# CITY OF ALBUQUERQUE

June 6, 2013, 2013

**Re: Hans Wittler Automotive, 121 Elizabeth St. NE, Traffic Circulation Layout,  
Architect's Stamp dated 5-30-13 (K21-D034)**

C1.1

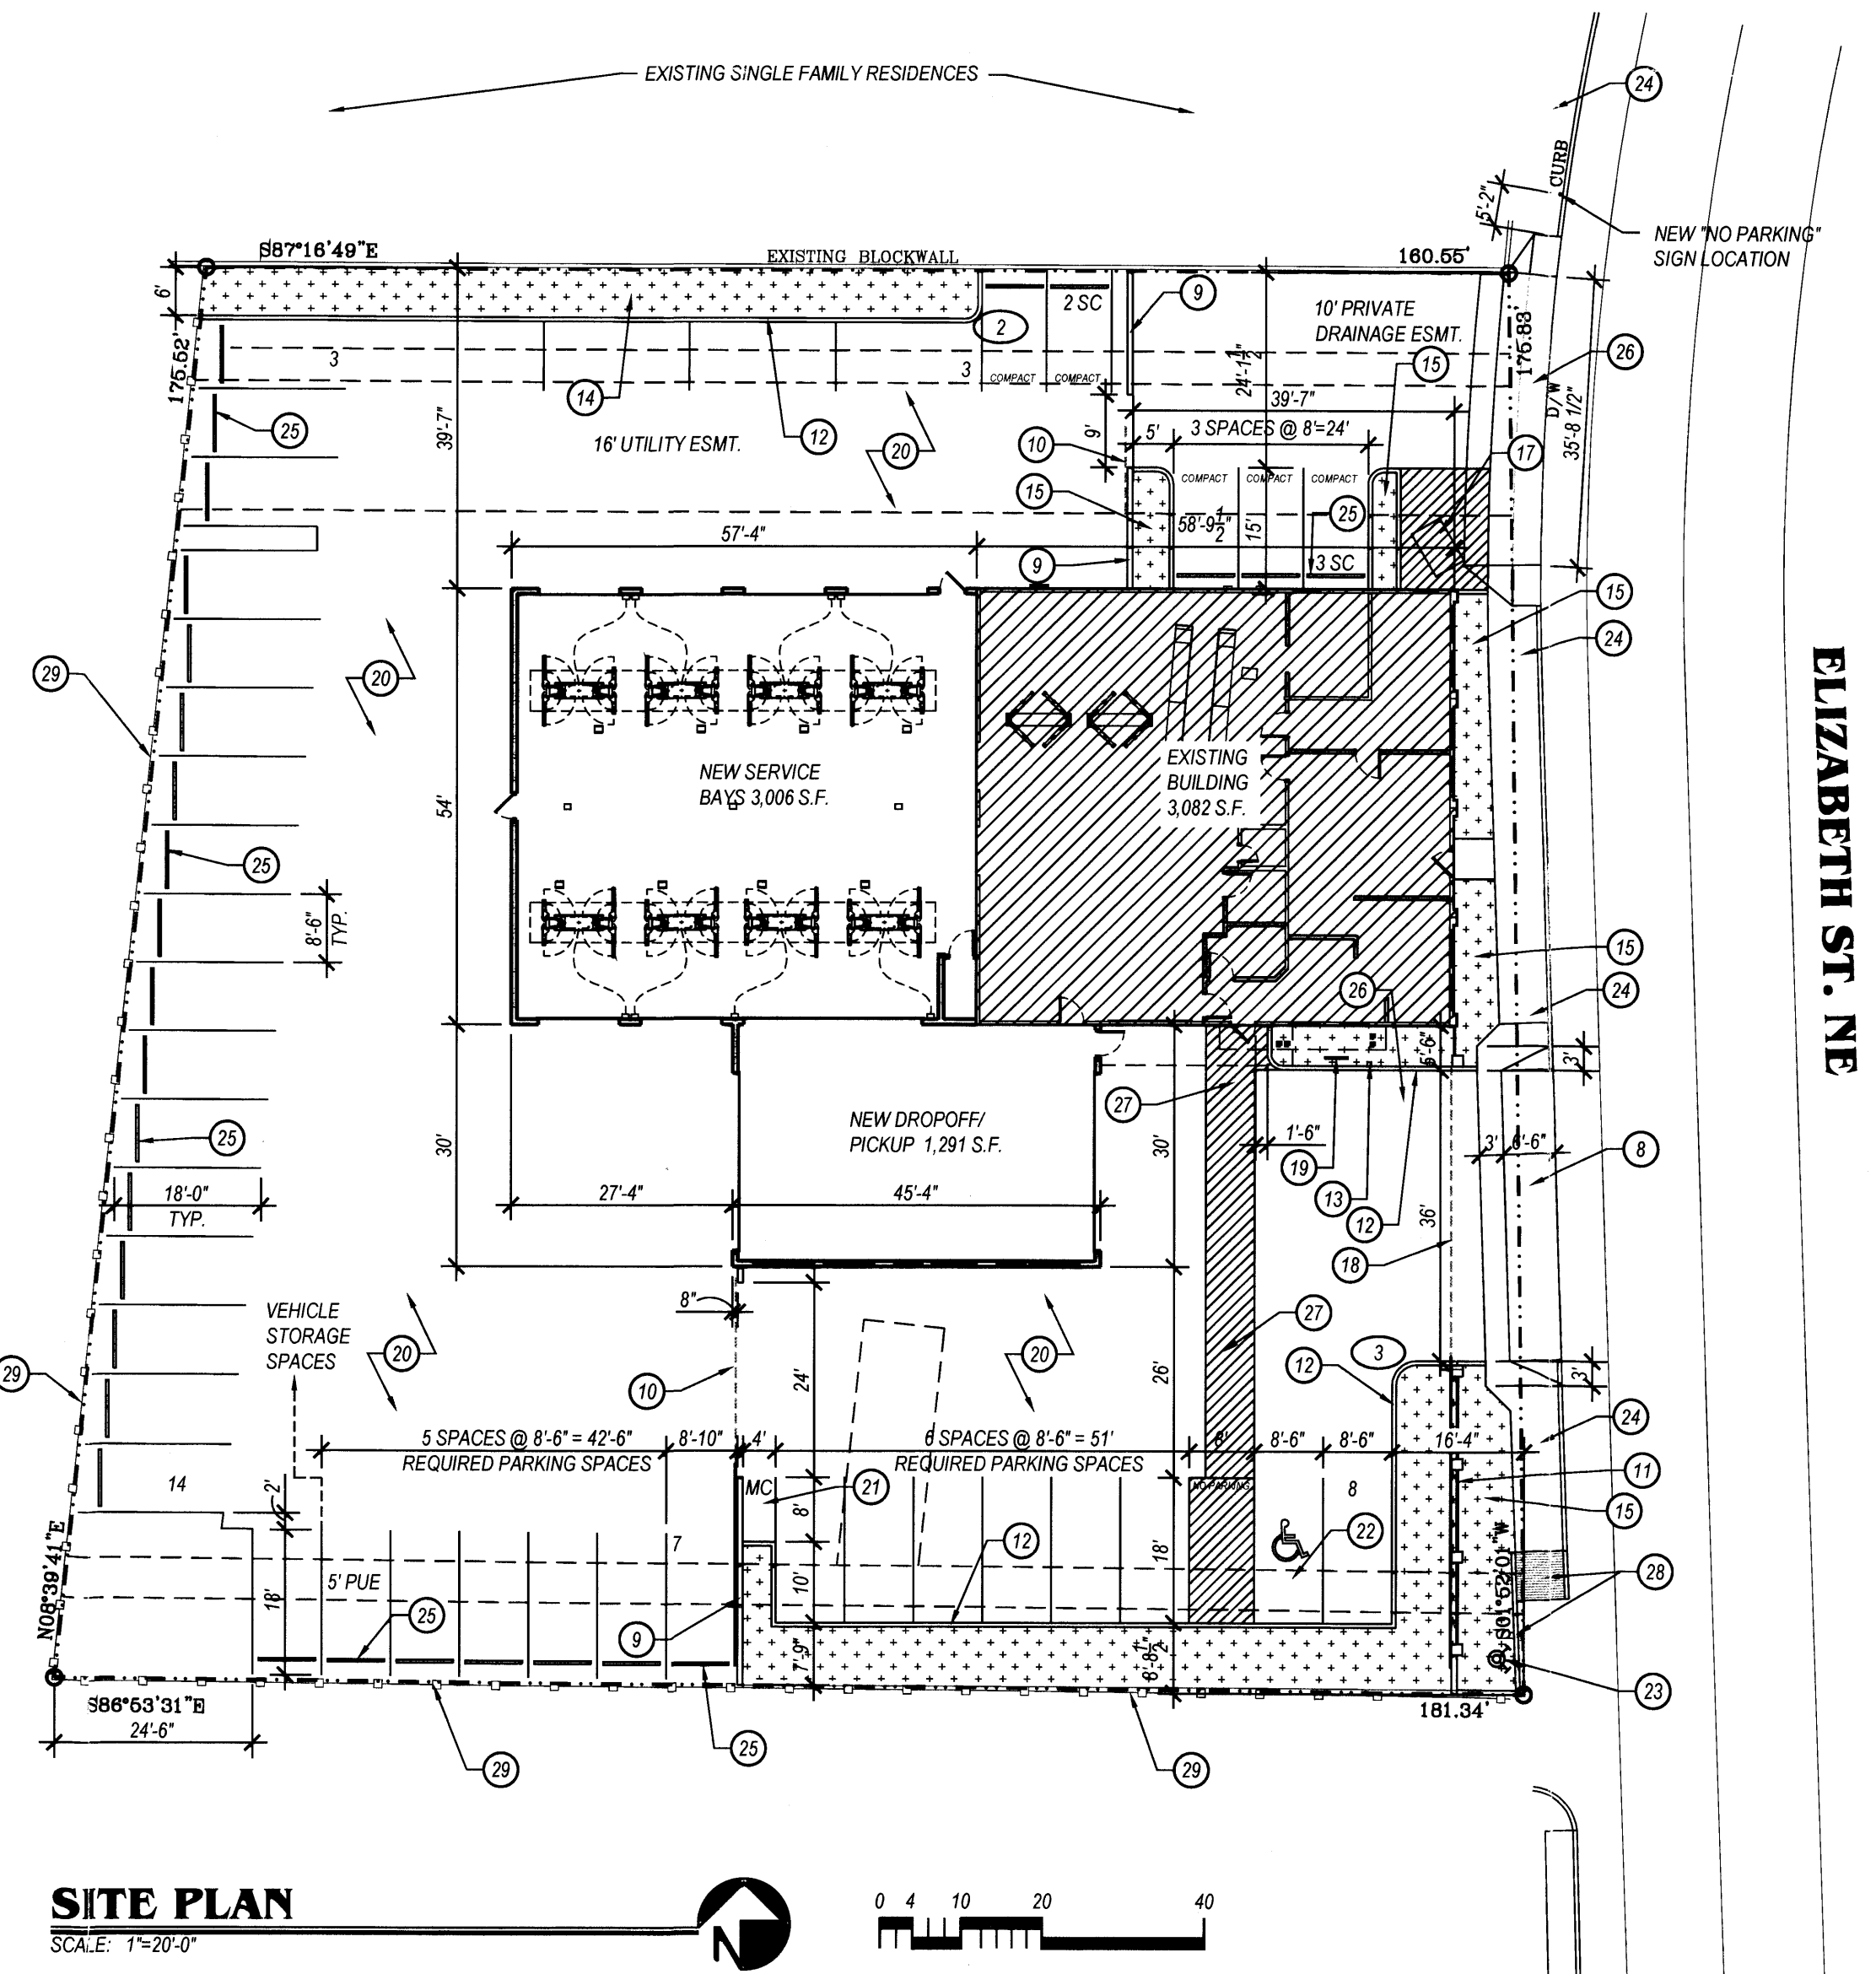
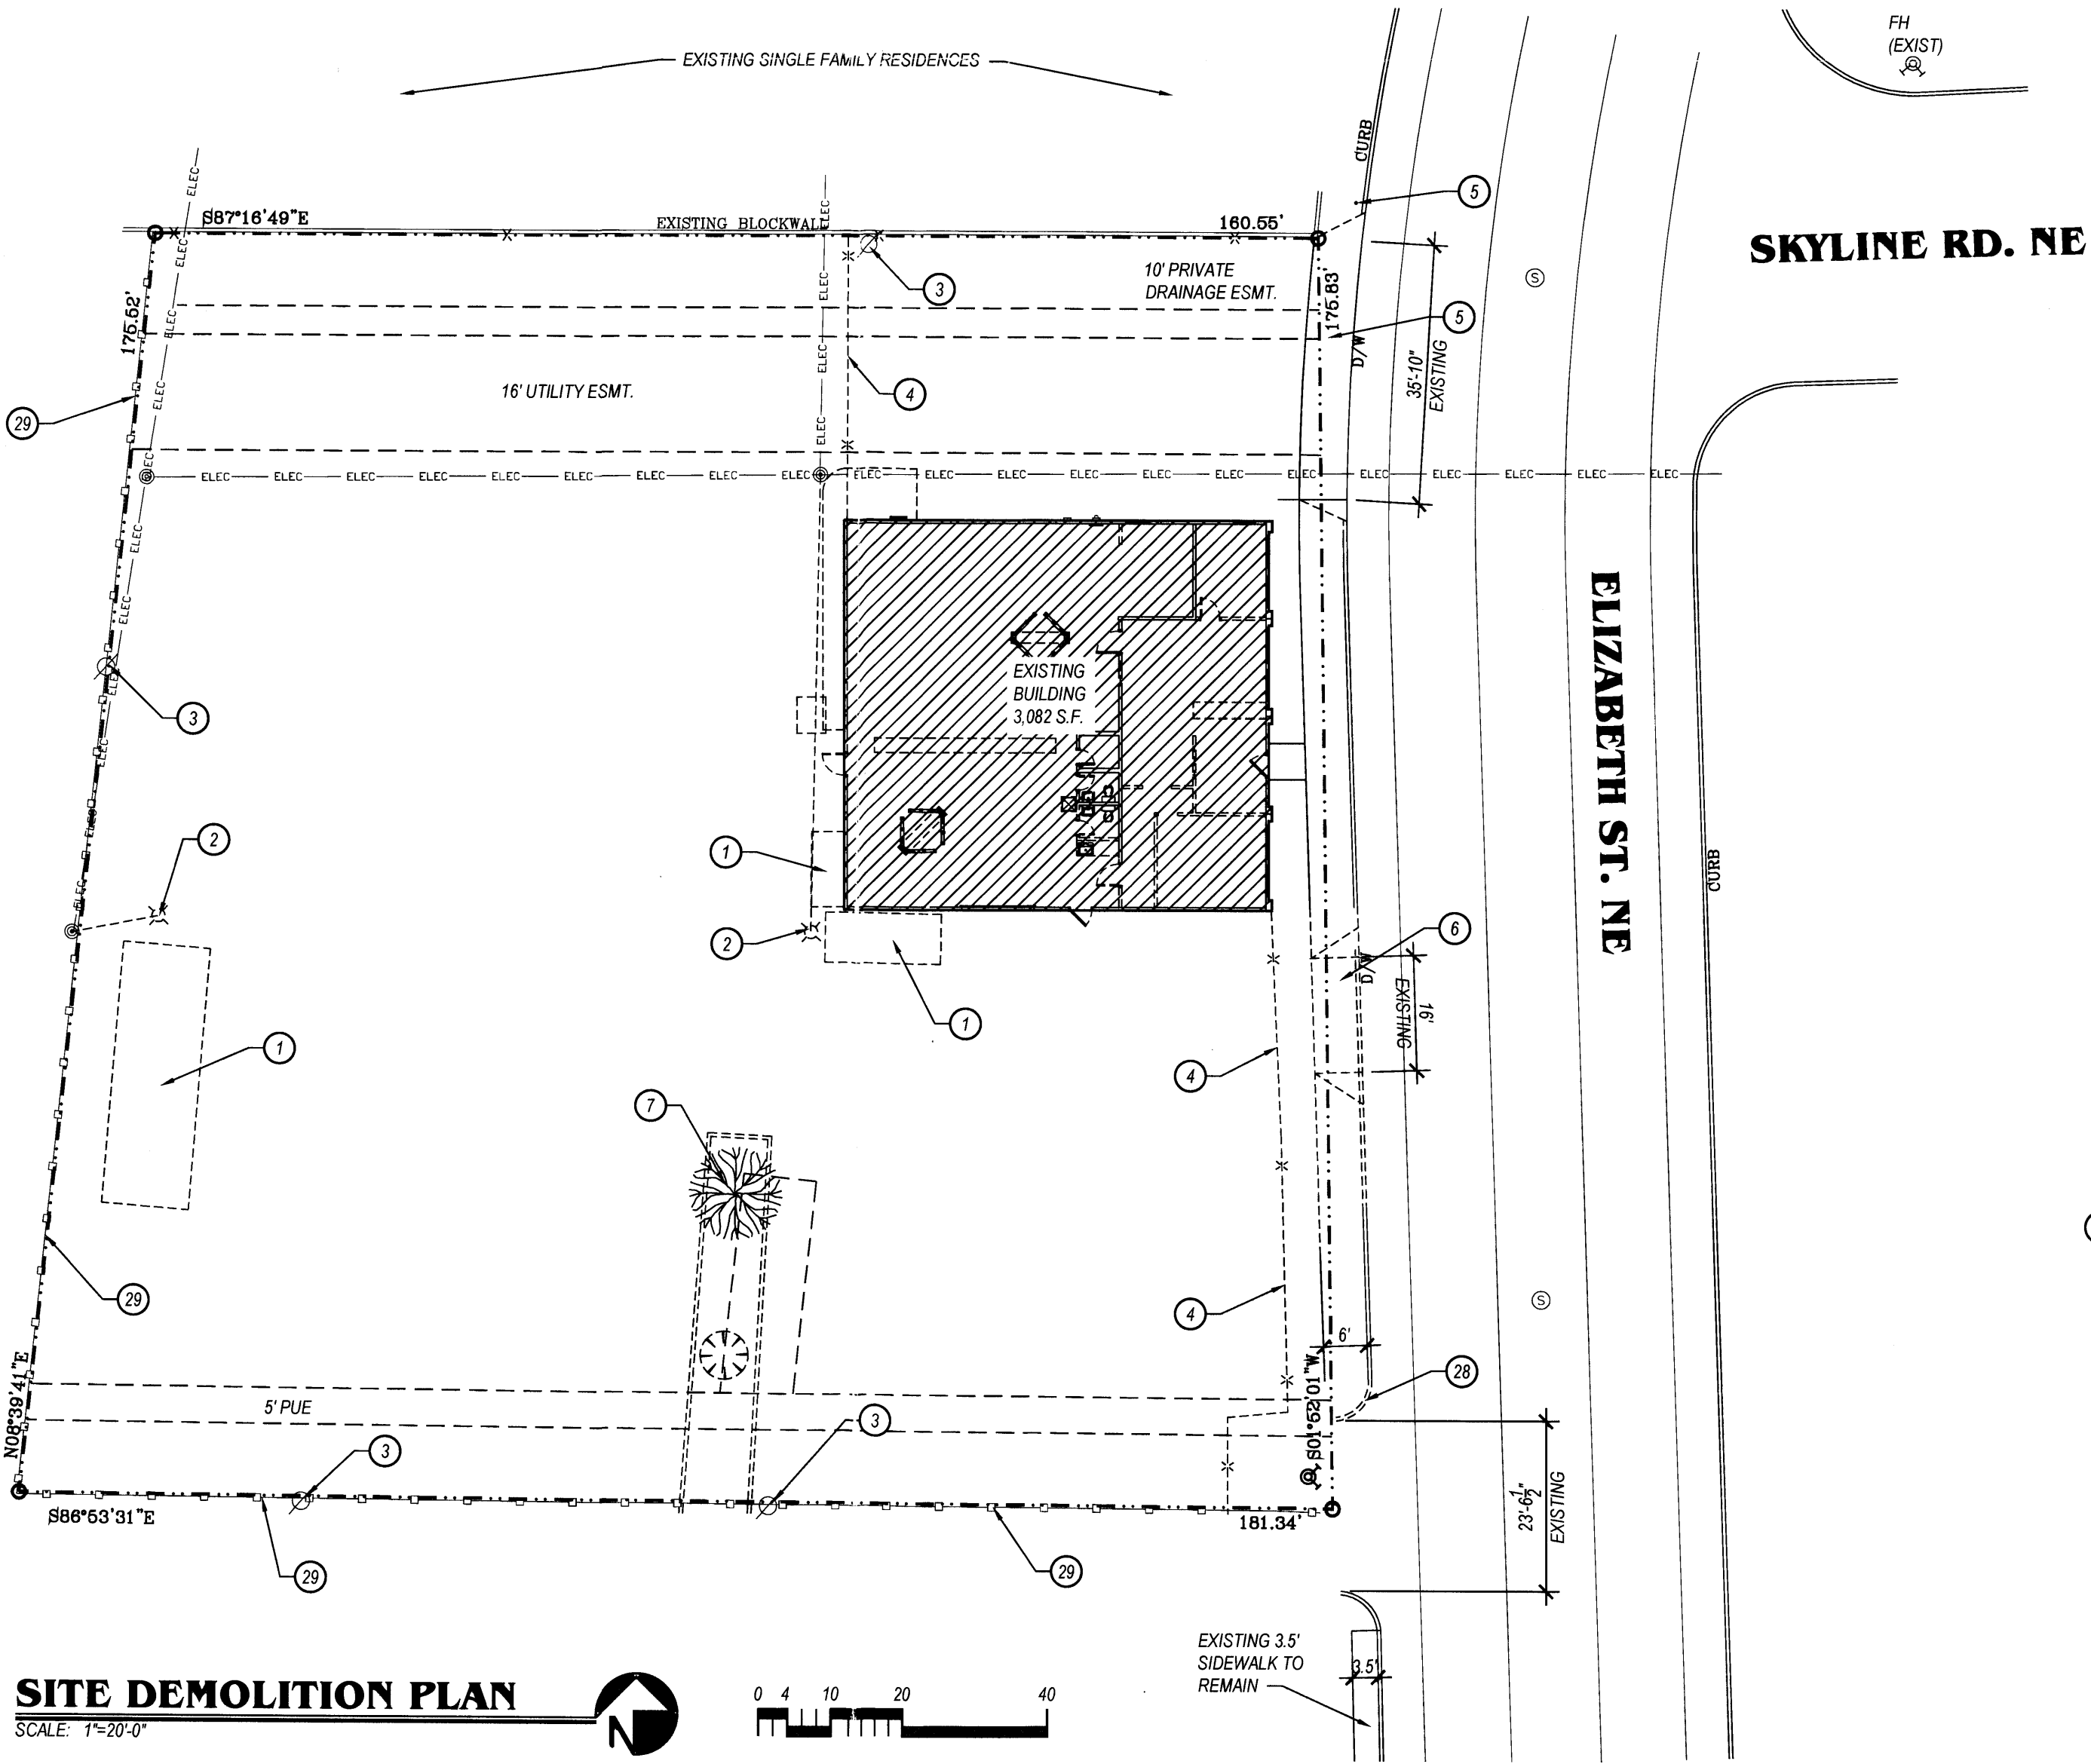
1. Define width of the existing sidewalk.
2. Keyed note #16, new city sidewalk, needs to include new curb and gutter per COA detail #2415A.
3. Does the COA sidewalk encroach onto private property? If so, a Sidewalk Easement will need to be obtained.

4. Show a detail of the wheelchair ramps located at the proposed driveway, or refer to the appropriate city standard.
5. The site plan indicates an existing curb cut between site and adjacent property to the north. This curb cut must be removed and replaced with sidewalk, curb and gutter per COA standards.

6. Parking areas shall have barriers which prevent vehicle encroachment and which shall be located two feet from any abutting lot, wall or fence.
7. Pedestrian walkway shall be provided from street sidewalk to the principal customer entrance. It shall be a minimum of six feet in width, unobstructed, clearly demarcated, and ADA accessible.

8. Pedestrian walkways shall be provided from handicap parking access aisle to the principal customer entrance. It shall be a minimum of six feet in width, unobstructed and clearly demarcated, and ADA accessible.

9. General site note F should read "per MUTCD standards" not NMSHTD.
